**RE: NEW WEE WAA HIGH SCHOOL (SSD-21854025)
REQUEST FOR ADDITIONAL INFORMATION**

This letter has been prepared by Ethos Urban on behalf of NSW Department of Education (DoE) in response to the Department of Planning's (DPE) Request for Information (RFI) in relation to the New Wee Waa High School (SSD-21854025), dated 29 April 2022 as well as DPE's follow up request sent by email on 20 May 2022. This letter provides a response to the issues raised by DPE and is accompanied by the following:

PLAN VIEW: Proposed Tree Removal Plan view (Fig 3) 4576 /WD1104 / B

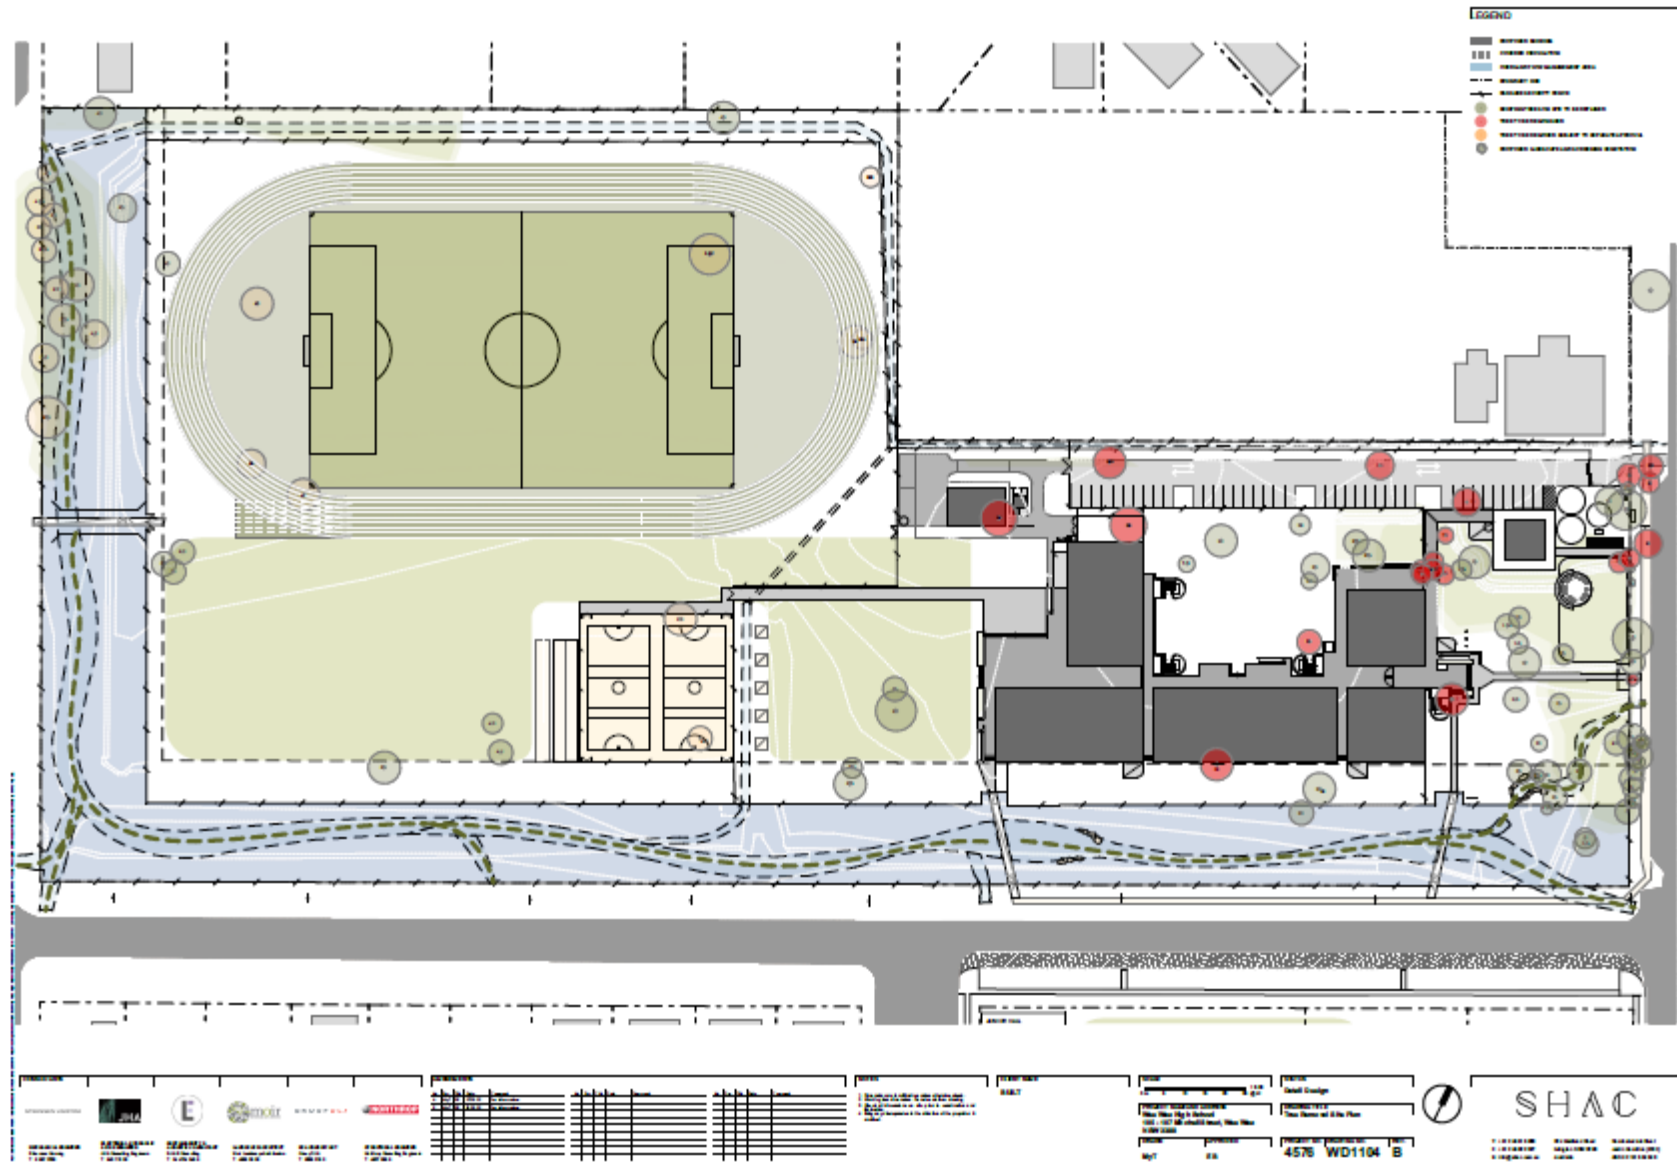
DPE raised concerns that the list of trees proposed for removal in the Submissions Report did not match the Arborist Report.

There are 31 trees proposed to be removed under this SSD Application: Tree 6, 6D, 7C, 7D, 8, 9, 9B, 10, 10A, 11, 12, 13, 14, 14A, 14B, 14C, 14D, 14E, 14F, 26, 27, 28, 29, 30, 31, 32, 33, 34, 35, 35A, and 54. Amended Architectural Drawings, Arboricultural Impact Assessment, Landscape Plans and BDAR have been co-ordinated and are provided as attachments to this RFI Response. A Tree Removal Plan prepared by SHAC is shown at **Figure 6**, which details all trees proposed to be removed in red.
